Please ask for: Nicola Moore
Email: nicola.moore@arun.gov.uk
Telephone: Ext 37944
Our Ref: AW/48/21/HH
Your Ref:
Date: 23rd February 2021

Application for Planning Permission for Works or Extension to a Dwelling

Development: Roof alterations to provide extension to existing first floor and swimming pool in rear garden
Location: 17 Kingsway Aldwick PO21 4DQ

roof plan
1 : 200

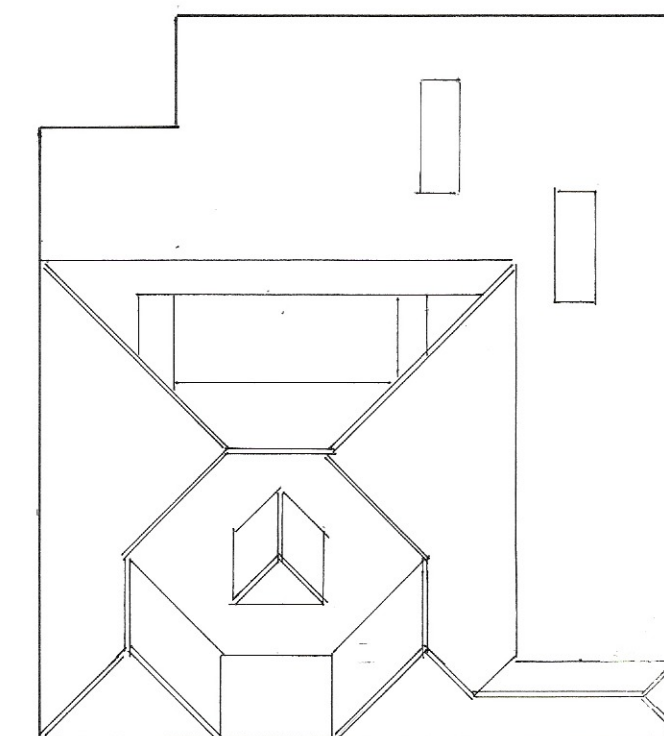
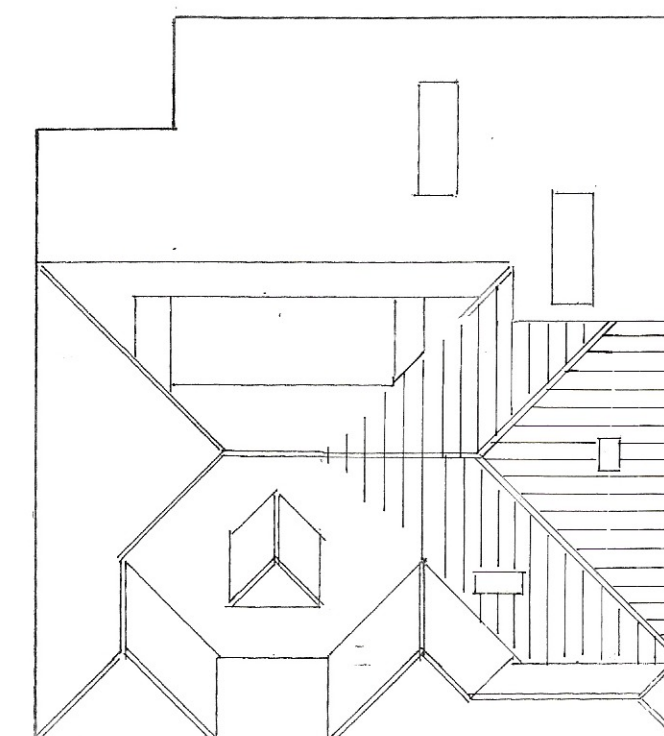
Roof Plan

Please submit 1 electronic or 3 paper copies of existing and proposed roof plan. Please refer to the Validation Requirements List for further details.
